**Re: Springvale Mine Extension Project (SSD-5594)**

Structure Substation

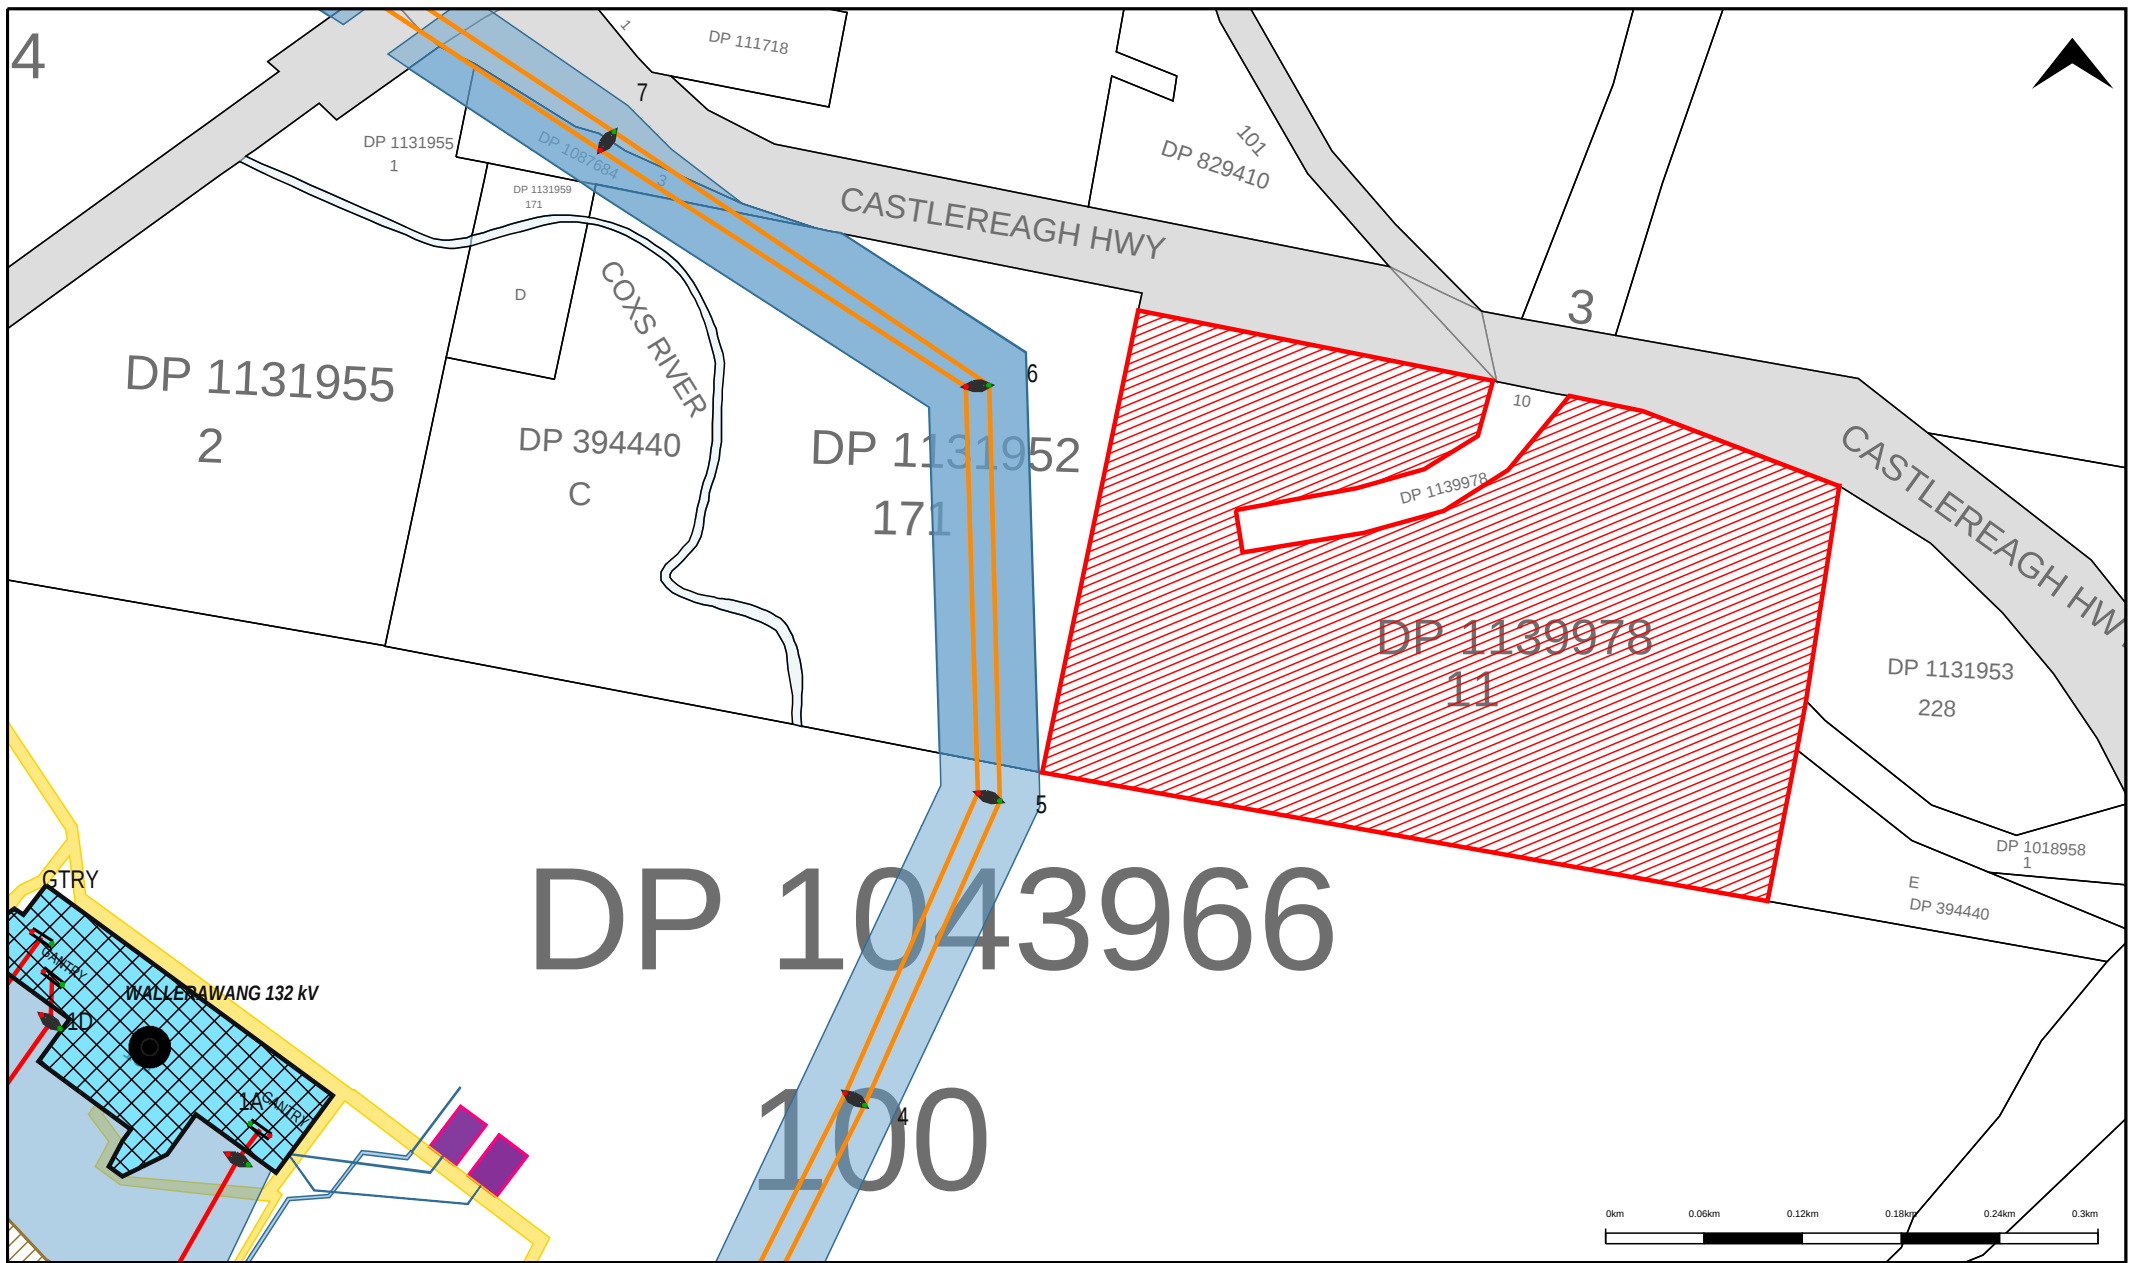
Lot 11 in DP1139978 is imminently close to TransGrid's *Wallerawang 330KV Transmission Line Outlet Easement* and the State significant infrastructure situated therein (Feeder 70/71 Structure 5). Please refer to the attached TAMIS plan. The south west corner of this parcel of land (Lot 5 in DP1139978) is located only 2 metres from the outer edge of TransGrid's easement; approximately 26 metres from the actual transmission line catenary (even less when the transmission line is at maximum operating temperature) and within 29 metres of the transmission line stanchion (tower). Horizontal clearances apply to all TransGrid easements and infrastructure, especially near stanchions that are constructed with subterranean earthing straps that protrude at least 15 metres diagonally from each leg of the tower. Therefore, no excavation or other earth works are to be undertaken near this tower. Further, the land near TransGrid's easements and infrastructure must not become vulnerable to mine subsidence.

A safe working platform must also be preserved along the easement and surrounding land, so maintenance can be undertaken to the transmission line and structures. Please find attached a pictorial example of the safe working platform that needs to be preserved around TransGrid's stanchions. As the transmission line changes direction at the location of Structure 5 (Feeder 70/71), it is particularly important to preserve a safe working platform around this structure which should be at least a 50 metre radius.
